Your Ref: OWPC20026
Our Ref: R/188/18/HH 25-07-2018
Please ask for:
Zac Denton

One & two storey extension to (South) side & rear (East)
81 Sea Avenue Rustington

Thank you for your internet representation made on 22nd September 2018 which has been recorded as '**an objection**' with the comments as follows:

PROPOSED FLOOR PLANS, ELEVATIONS,
ROOF PLAN & BLOCK
81 Sea Avenue
Rustington
West Sussex
BN16 2DR

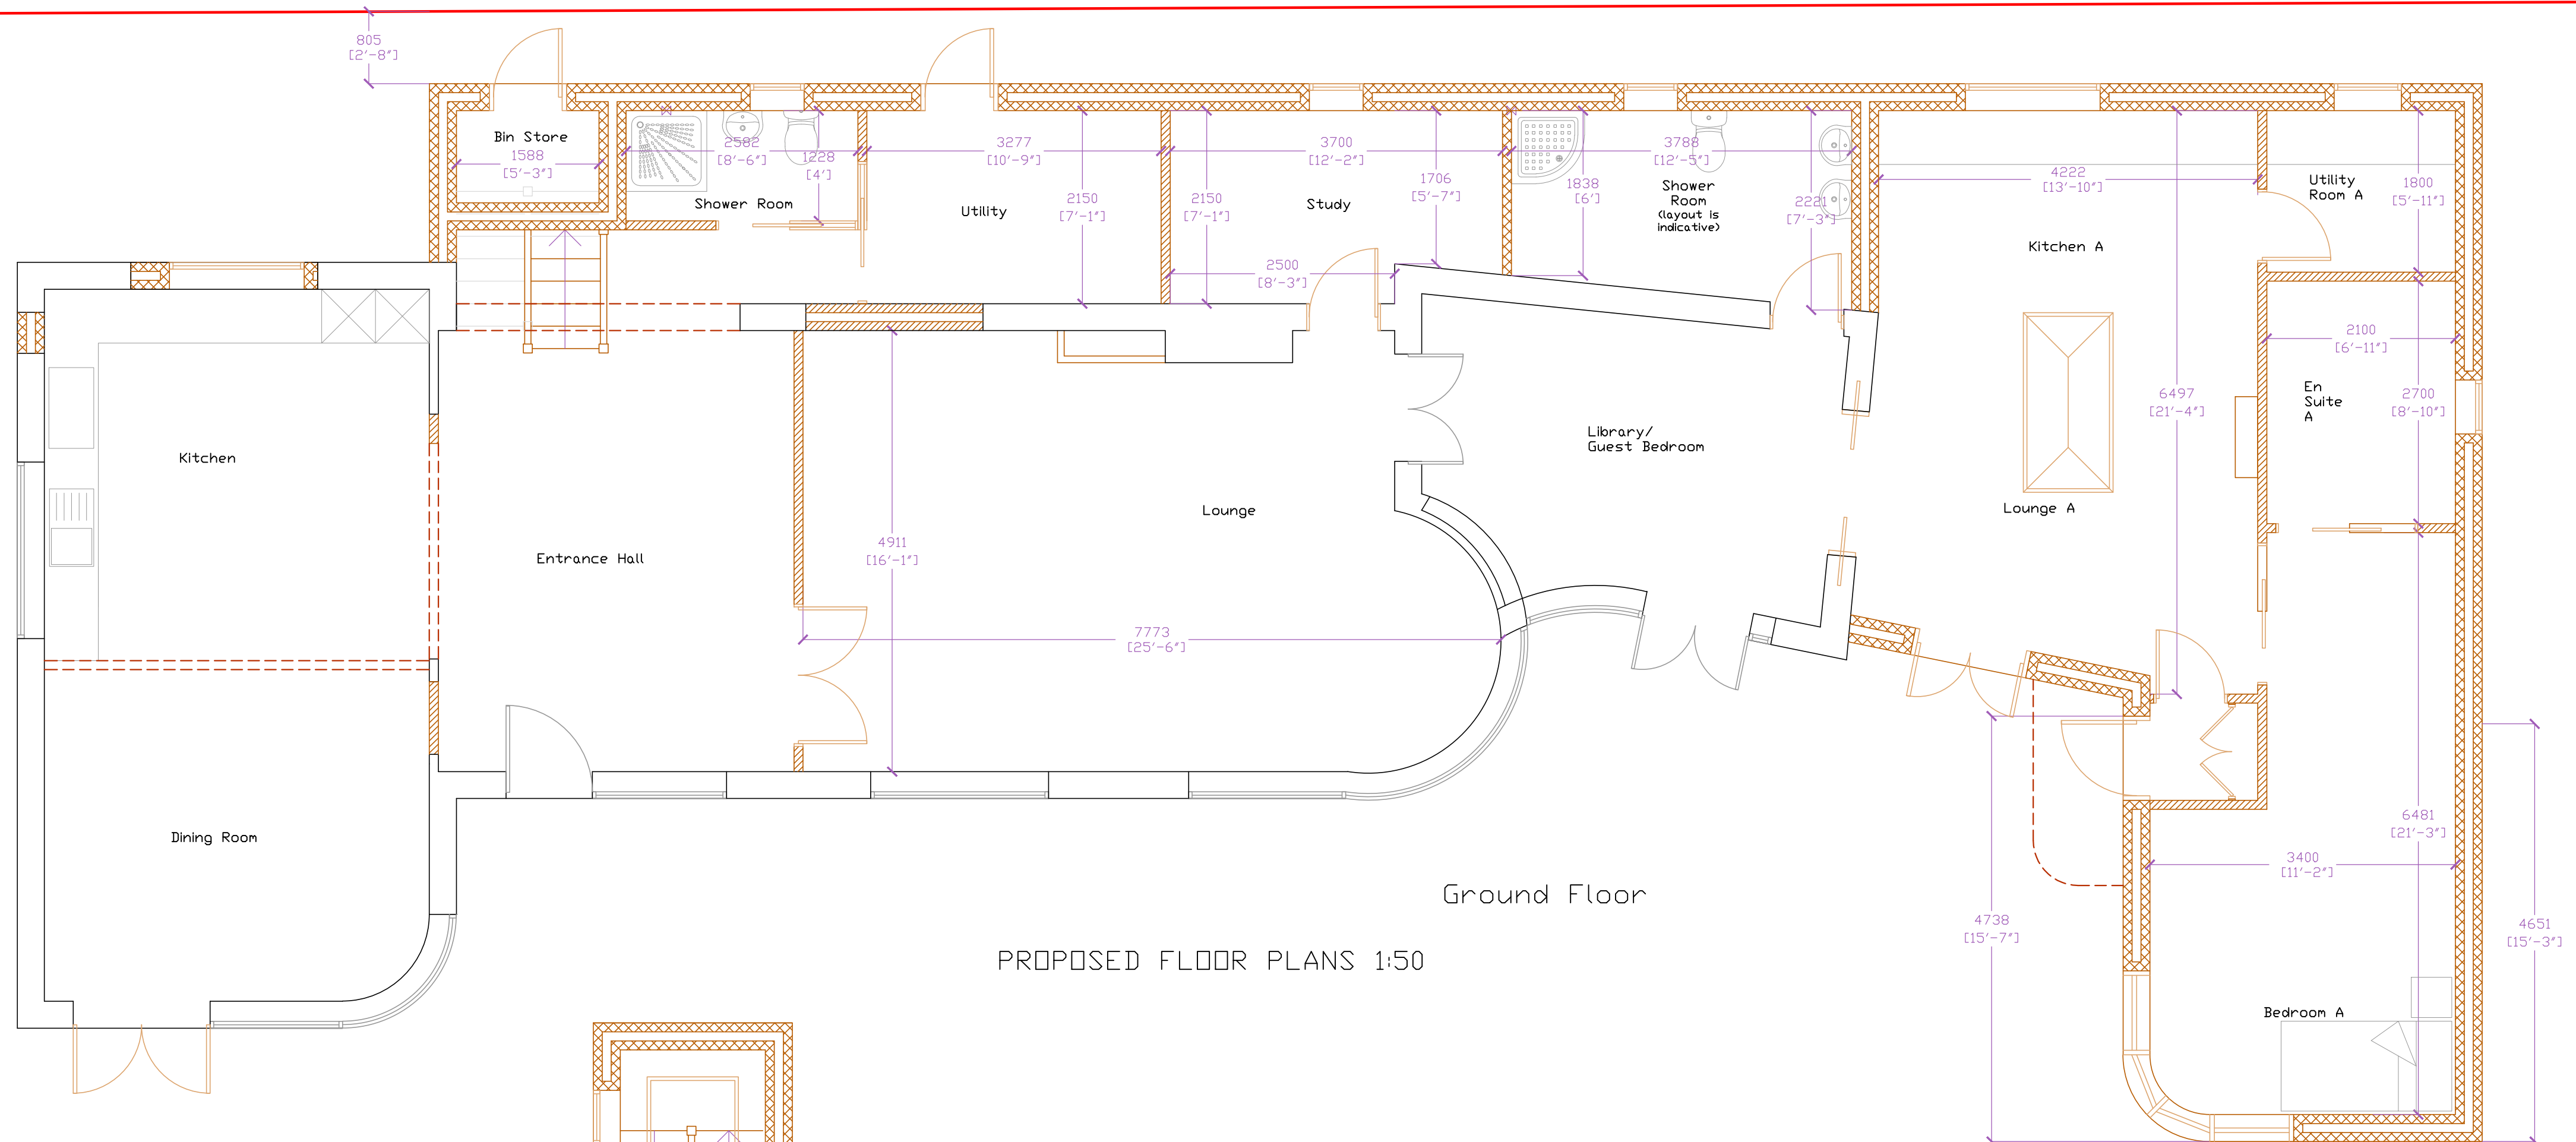
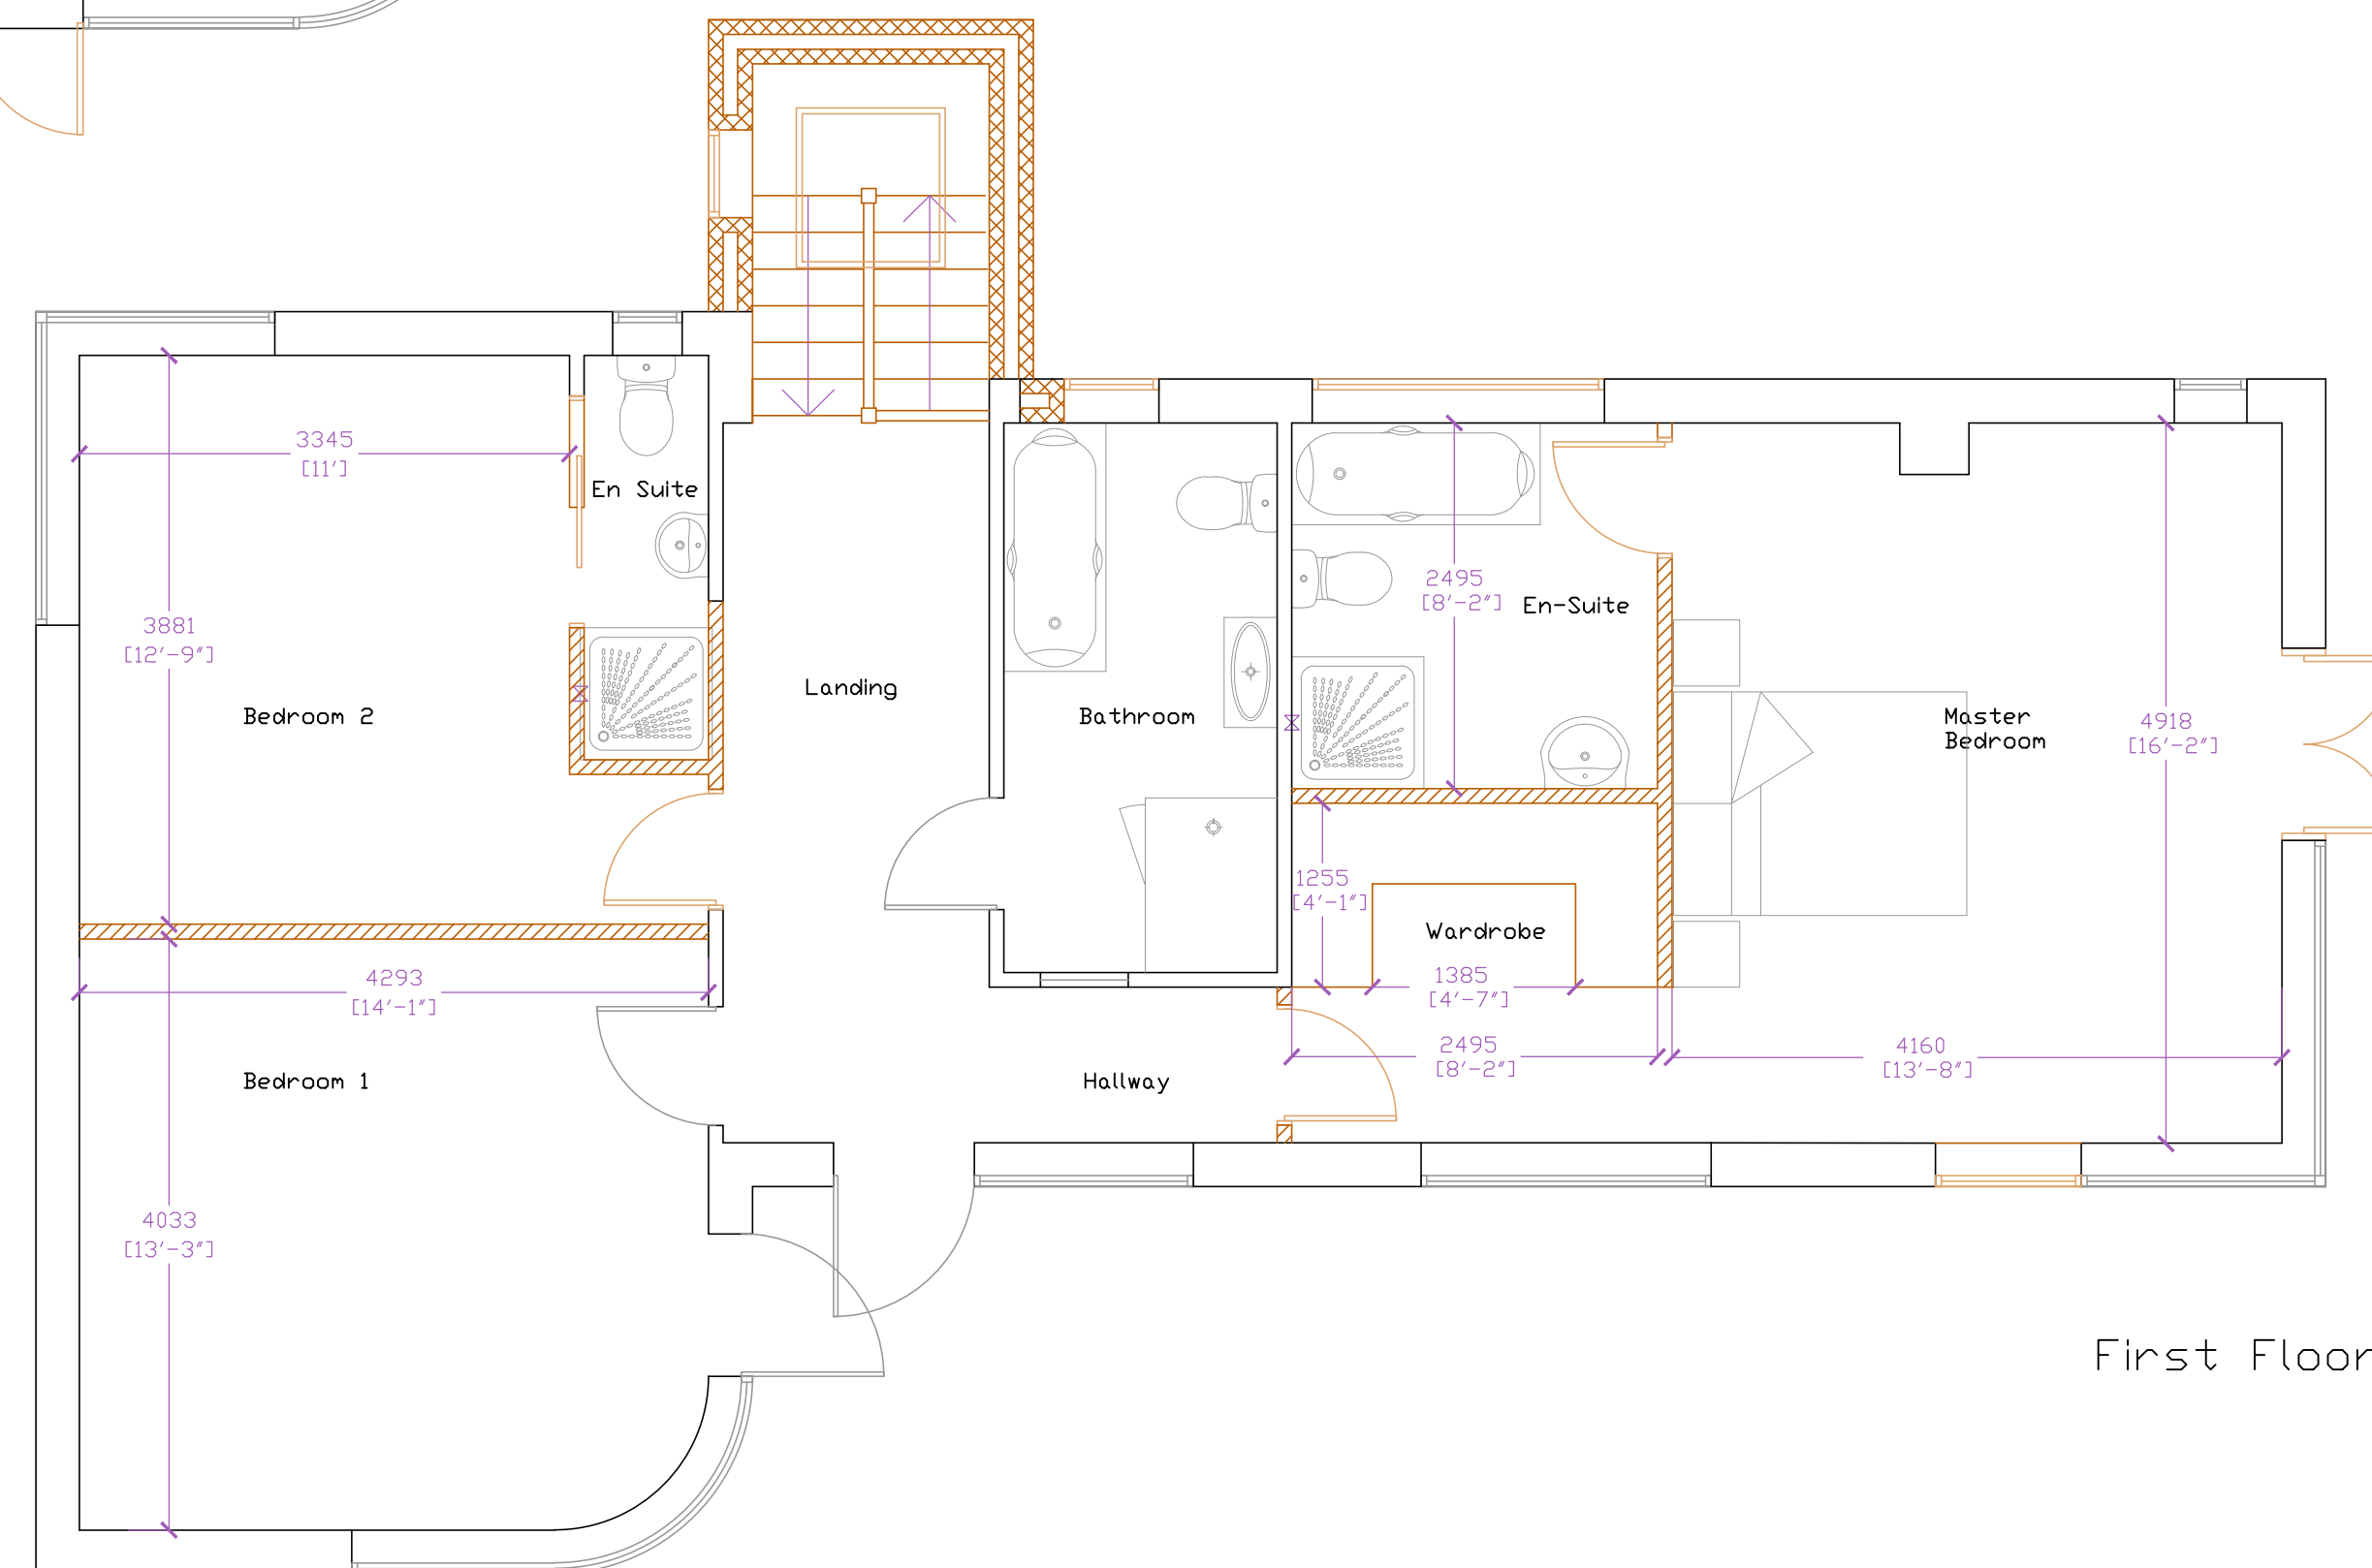
In particular there is a large, mature Magnolia tree (30+ feet tall) which has stood at least since 1936 for which there is photographic evidence. The proposal shows that the East elevation two storey and single

extension will only leave 800 mm between the extension wall and the boundary fence, meaning that this is incompatible with the retention of this distinctive tree. Should the Magnolia have to be felled, the applicant's privacy will also be impacted because the balcony will be visible from a number of nearby properties.
